Response to Submissions

SSD-10349-Modification 2

TAFE Meadowbank - Multi-Trades and Digital Technology Hub

MULTISTOREY CARPARK WINTER
SHADOW DIAGRAMS IMPACT STUDY

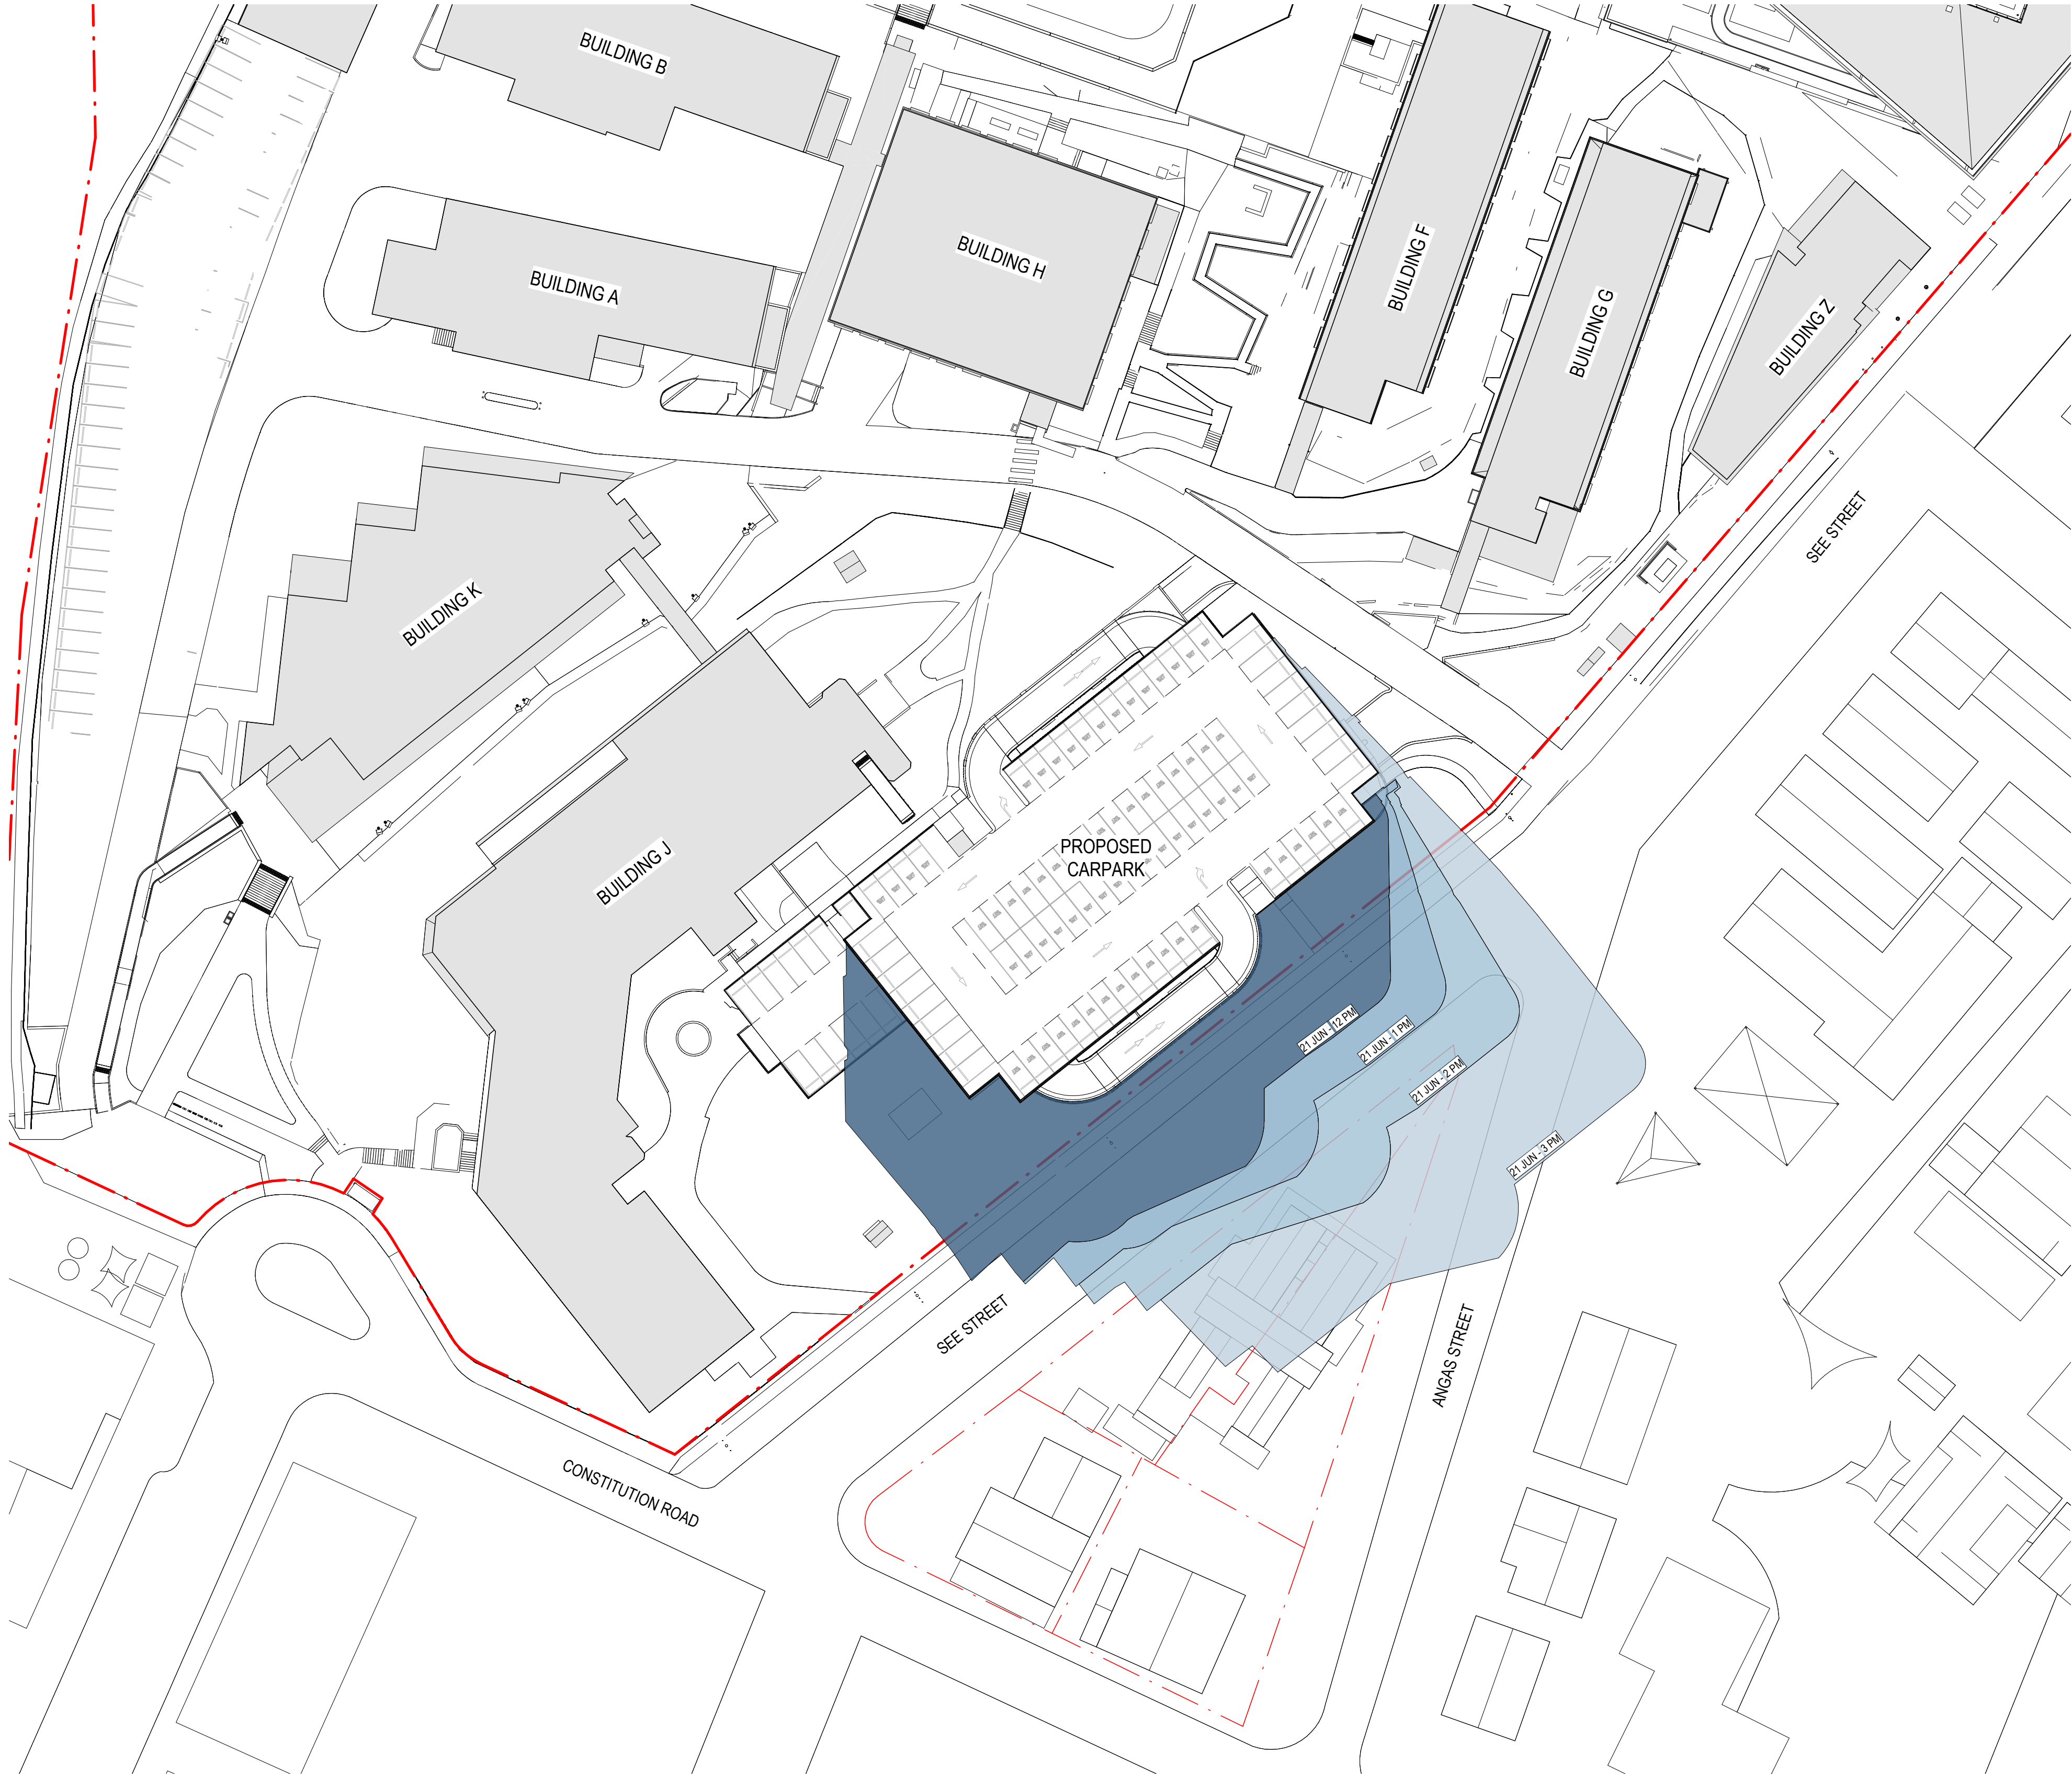
Public Submission	Response
<p><i>The most significant impact the additional 2 levels will have on the surrounding area are on the Shadows cast over the buildings at 34 See Street and 1a Angas Street. This building will shroud the buildings and yards in shade where the current building only has a minor impact. I have attached for your review the Specific Architectural drawings SHADOW DIAGRAMS IMPACT STUDY, see “2. Appendix B_Architectural Drawings_Carpark pg9” and “Mod2 Appendix 2 - Architectural Plans pg8” to illustrate the impact. This is not acceptable.</i></p> <p><i>I also object to the direction of the traffic flow within the Multi storey car park as the Up-ramps to the higher levels are facing the street. This will increase the car noises that will reverberate across the road to residential dwellings and a Primary School. The Up-ramps should have been placed on the Western side of the building and the noise retained within the TAFE precinct. This can still be changed before the opening and final stages of the current multi storey car park.</i></p> <p><i>I object that the additions that are being proposed to a public building are to make the building a viable proposition to sell this to a private Company, who will charge staff and students. The majority of the TAFE Students are starting out in their working life and have little income, so they will not have spare cash to spend on parking in the car park. The previous Open car park opposite 10 See Street was not fully utilised while there was a menial charge. The TAFE students wouldn’t pay to Park as they want to save money so they will then clog the Streets around Meadowbank. If the intent is to make this a Commuter car park that will defeat the whole purpose as to why this was being built in the 1st place and increase traffic through the back streets of West Ryde, Ryde and Meadowbank.</i></p> <p><i>The Current Car park needs to be Free for TAFE Staff and Students to free up the Streets currently made unsafe by the Staff and Students that have to move their cars every 2 hours in fear of council park rangers booking them. There is a Day Care next to the Car park in the TAFE grounds, across the road in Angas street as well as the Italian Bilingual School from K to 6 and the</i></p>	<p>was formerly used as a nursing home, but this use has ceased. Regardless of the status of operation of the nursing home, the building itself still embodies heritage significance.</p> <p>The assessment provided in the Heritage Impact Assessment concludes the proposed amendment will not have any further impact on the visual amenity of the surrounding heritage items.</p> <p>Overshadowing</p> <p>The proposed modification ensures minimal impact to the amenity of the adjoining residences, with overshadowing kept predominately to See Street, utilising the favourable north to south orientation of the site. As a result, the additional levels will not result in any additional overshadowing of residential properties on See Street until approximately 5pm at the winter solstice.</p> <p>Traffic Impacts – Noise and Flow</p> <p>In accordance with the Noise and Vibration Assessment prepared by JHA (submitted with the application), suitable management measures will be implemented to ensure noise emissions are not intrusive and do not impact on the amenity of nearby residential properties.</p> <p>With regard to traffic flows, the Response to Transport-Related Submissions (Attachment 2) details that vehicle circulation is consistent with the approved lower levels of the MSCP.</p> <p><i>Vehicle circulation is consistent with the lower levels of the car park. The current configuration of the car park and the ramps is considered appropriate, as it seeks to separate inbound vehicles to the eastern side of the car park and outbound vehicles to the western side of the car park, resulting in efficient</i></p>
